Planning Application No: 3/2025/0945
Grid Ref: 373644 436723
Proposal: Proposed single-storey side and rear extension.
Location: 4a Wiswell Lane Whalley BB7 9AF

Whalley Parish Council wishes to submit the following comments regarding the above application:

PROPOSED SITE PLAN

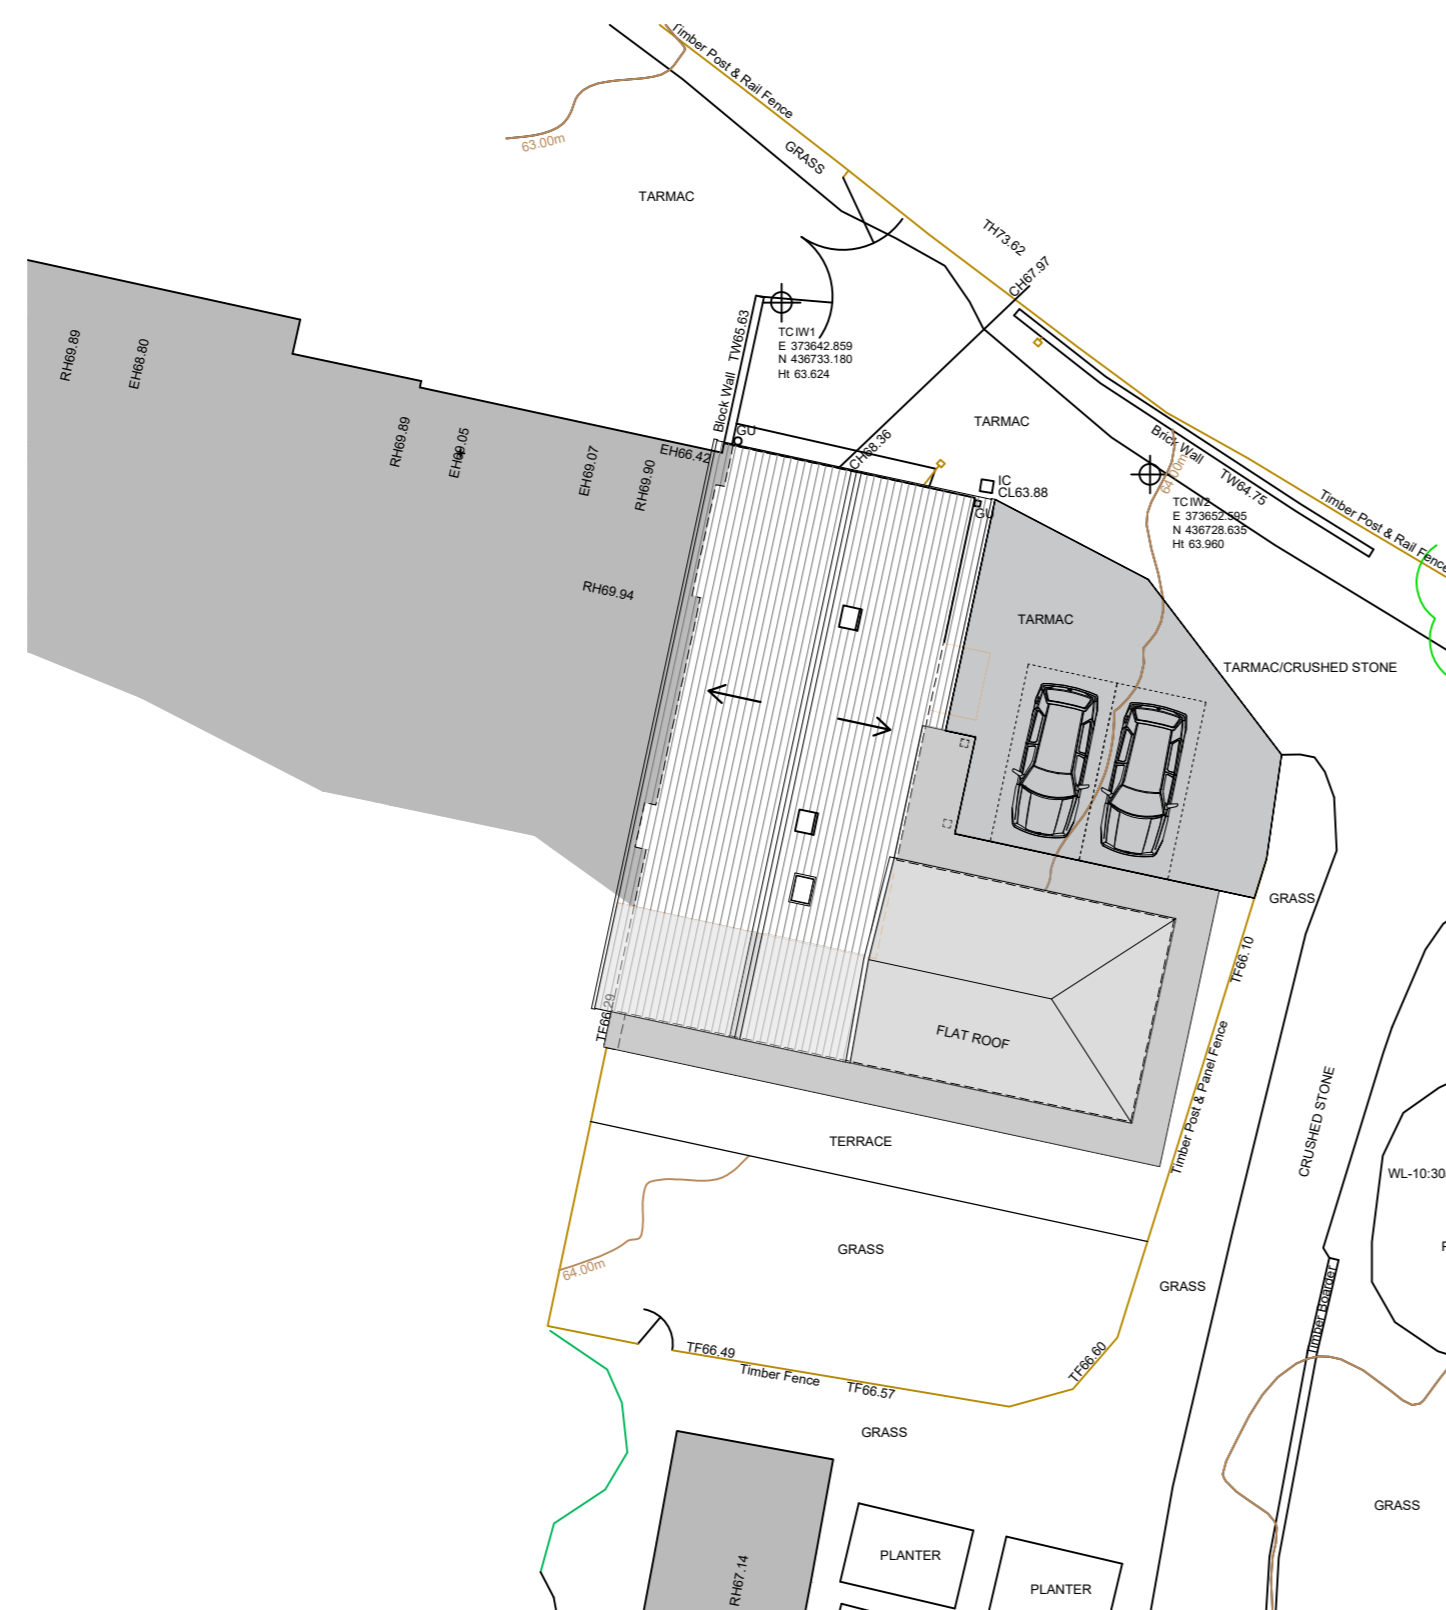
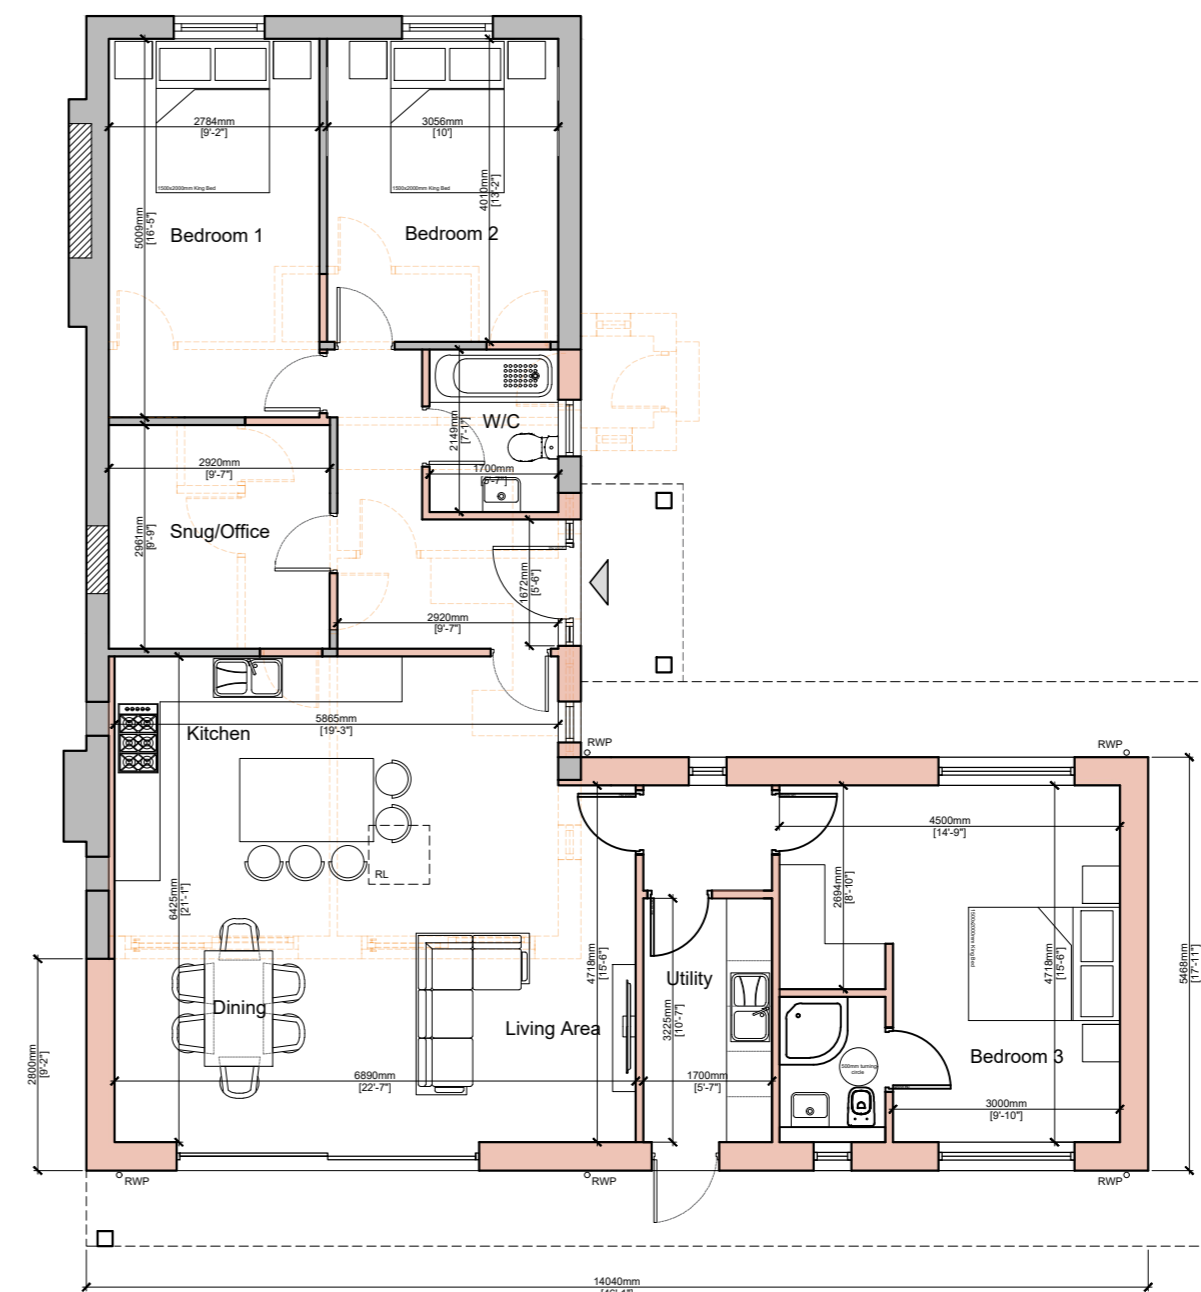
- 1. Clarification on Existing Site Structures**
The Council requests further information to clarify whether the chalet referred to in the previous application is still present, as it does not appear on the drawings submitted with this application.
- 2. Impact on Parking and Traffic**
The Council seeks to understand whether the presence or absence of the chalet will affect parking provision and traffic movement associated with the proposed development.
- 3. Relationship to Pending Appeal**
The Council notes that there is an outstanding planning appeal for application 3/2024/0851. The Parish Council requests that the planning authority consider whether this application should be determined prior to the outcome of that appeal, given the potential implications on the site.
